**Re: MODIFICATION TO MAJOR PROJECT 08_0088 AT 23 SCRIVENER STREET,
WARWICK FARM**

I write in response to your email dated 23 June 2011 in relation to the proposed modification to Major Project 08_0088 being the refurbishment and extension to an existing manufacturing plant to create a printing and warehouse/distribution facility at 23 Scrivener Street, Warwick Farm.

Figure 4: Part east building elevation showing additional flue

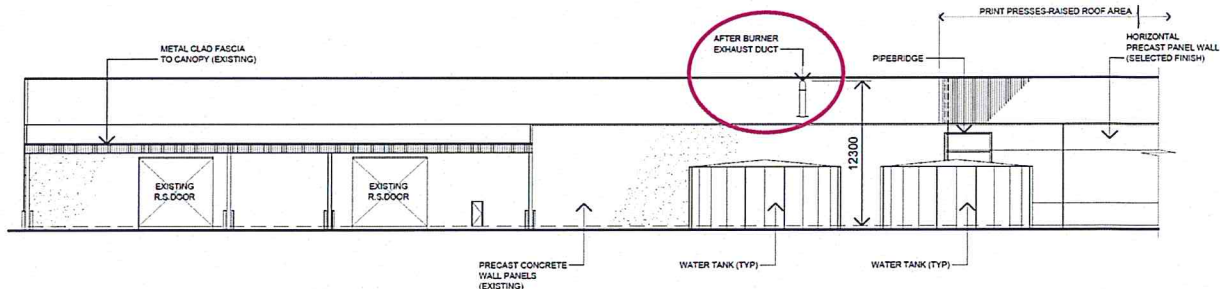
- That there are no adverse visual impacts as a consequence of the additional flute from existing residents on Scrivener Street and Priddle Street;
- That there are no adverse air quality impacts associated with the additional flute; and
- That there are no adverse visual impacts associated with the increase in height of the waste paper bailer equipment to existing residents on Priddle Street. It is considered that it may be appropriate that the proposed modification to incorporate screening devices to minimise any adverse visual impacts from Priddle Street.

Figure 5: Part south building elevation showing protruding waste rotary paper separator

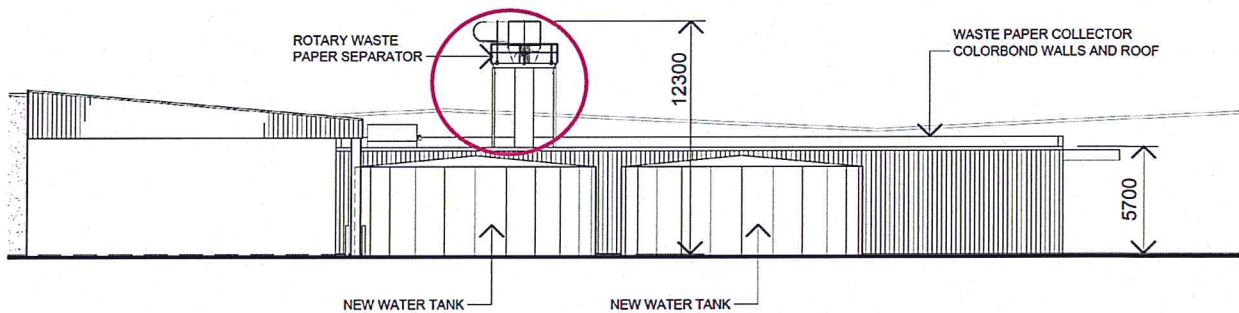
It is noted that the documentation accompanying the proposed modification did not provide any streetscape elevations to illustrate what could be viewed from residents at Priddle Street, in this instance it was difficult to ascertain the extent of the visual impact of the increase in the height of the waste paper bailer equipment.
